# ENG-SF20028-R2-Plat.pdf Markup Summary

**Subject:** Image  
**Page Index:** 1  
**Date:** 4/14/2021 1:35:09 PM  
**Author:** dsdparsons  
**Color:** ■  
**Layer:**  
**Space:**  
**Page Label:** [1] 2020-03-05 - Constitution & Hannah PLAT-S1

FILE NUMBER _____ ADD SF 20 028

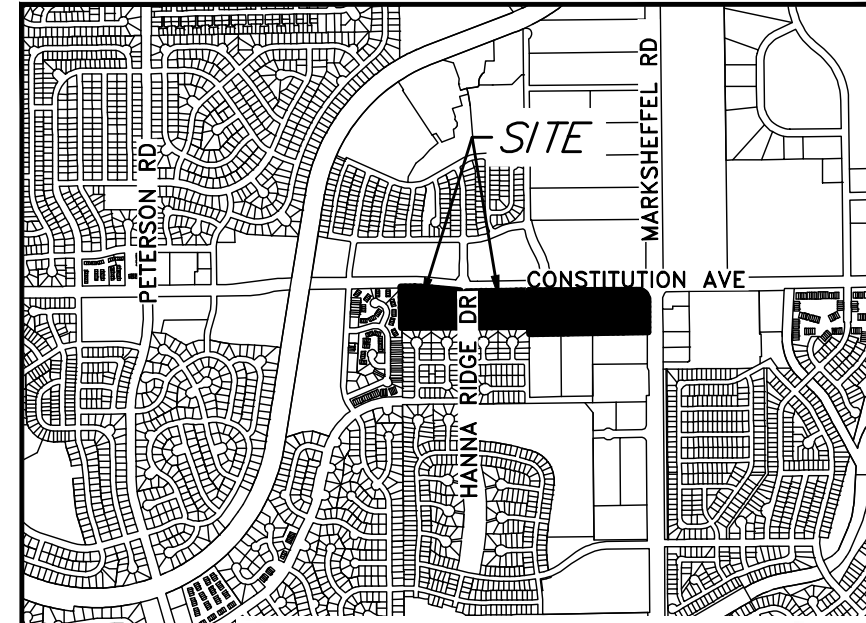
Please review a plat that as stated in review 1 for the standards. ADD the standard surveyor language above the legal.

ADD SF 20 028

This is odd; i dont recall this as a standard note in the County, (and the Code is 2019). DELETE THIS

you need a notary for each owner/ plat signer

This will be signed by the HOA ; please add the acceptance certificate like the example provided

this is still different from note 2 on sheet 2

If there are no public improvements delete the highlighted text.

Where is Tract N?

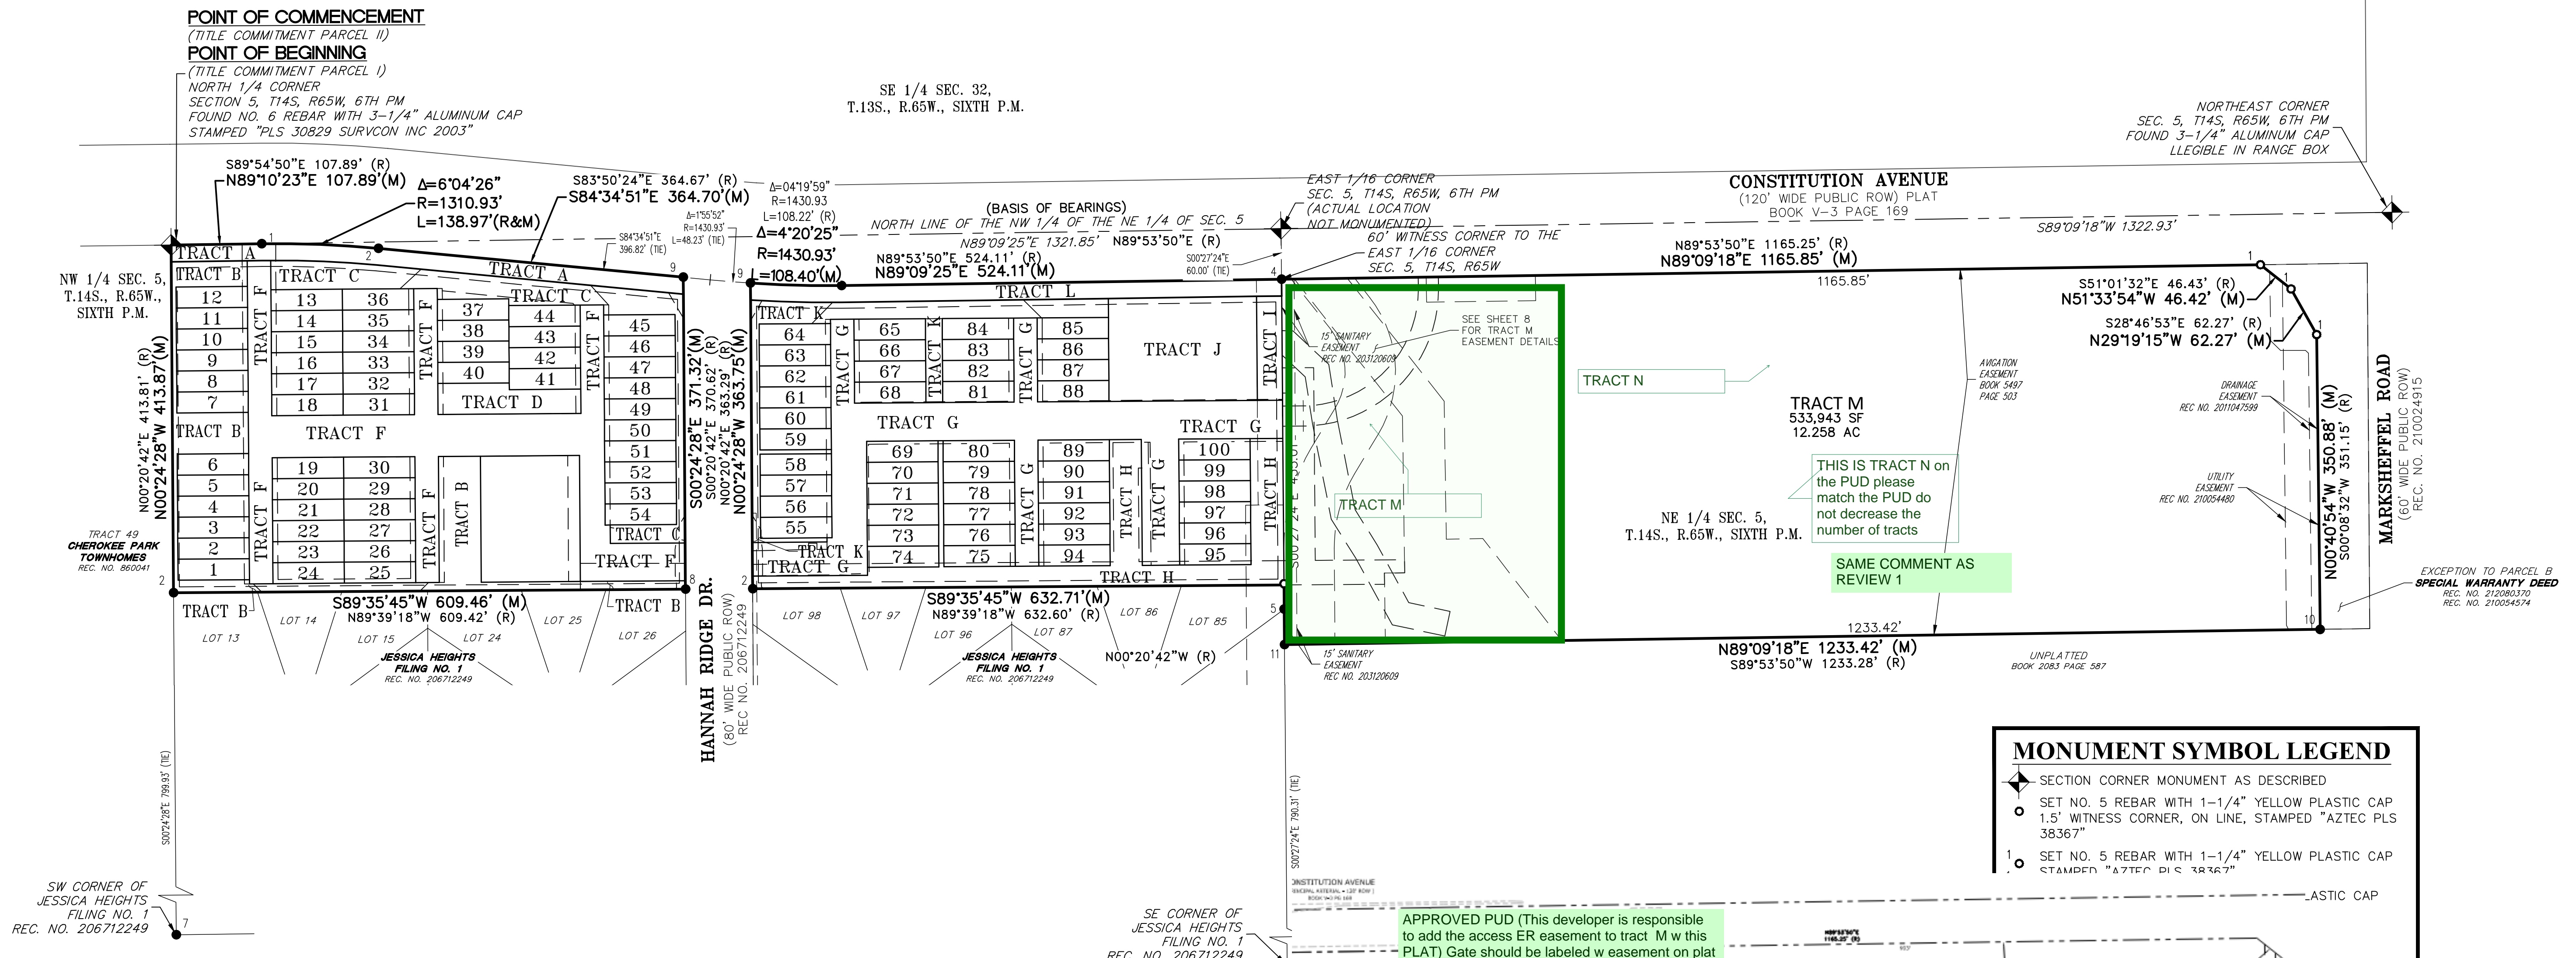
Verify the name of the HOA and be consistent;  
provide a copy of the Sec of State document  
creating the HOA so we can verify name of HOA.

Note 25 and 37 are  
duplicative (delete  
note 37)

Add the detention pond maintenance agreement note?

Repeat comment: Identify the gas, electric, water and sewer providers in a plat note for this project- For example

Because the HOA is to own and maintain drainage and tracts we need to have a maintenance agreement with HOA and verify that maintenance is included in HOA docs- provide HOA docs.

This is not a standard note? USE STANDRDS notes provided at sheet 1; provide these HOA docs

this is different from legal description on sheet 1

delete highlighted portion and replace with a sentence stating the HOA is the maintenance entity.

There shall be no direct lot access to Constitution Avenue, Marksheffel Road or Hannah Ridge Drive.

Verify whether or not the notes regarding airport noise (2) and Constitution Heights Metro District are needed.

-Tracts E and J are subject to a Private Detention Basin/Stormwater Quality BMP Maintenance Agreement and Easement as recorded at Reception No. \_\_\_\_\_ of the records of El Paso County. The Urban Collection at Palmer Village Duplex Owners Association is responsible for maintenance of the subject drainage facilities and the whole private storm drain system serving this subdivision.

Repeat comment / PUD

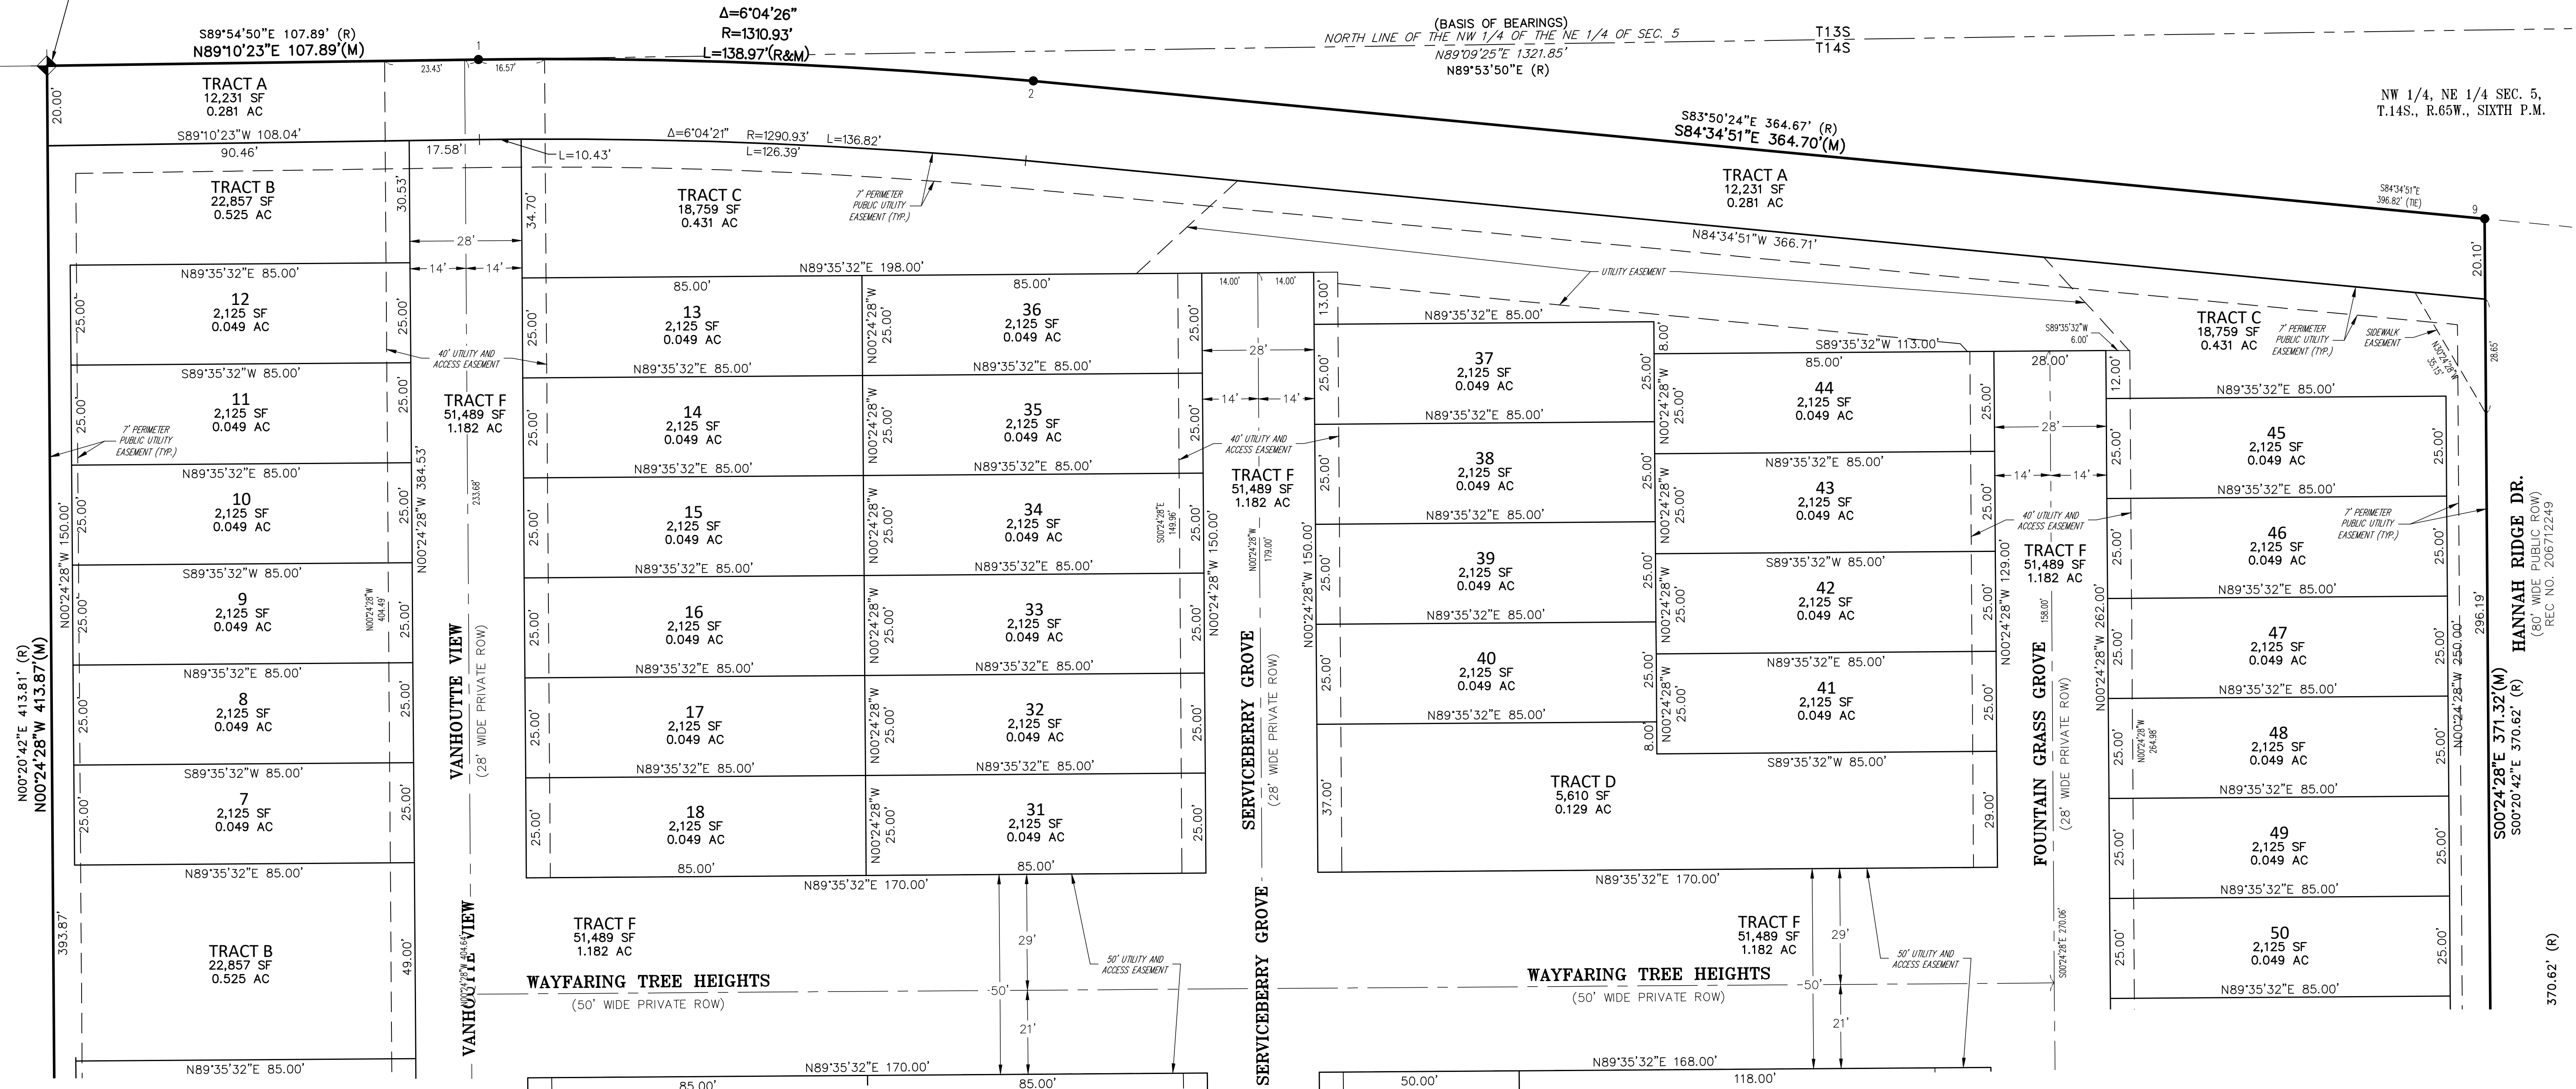
THIS IS TRACT N on the PUD please match the PUD do not decrease the number of tracts

SAME COMMENTS AS REVIEW 1 - TRACTS  
CANT CHANGE FROM PUD

APPROVED PUD (This developer is responsible to add the access ER easement to tract M w this PLAT) Gate should be labeled w easement on plat
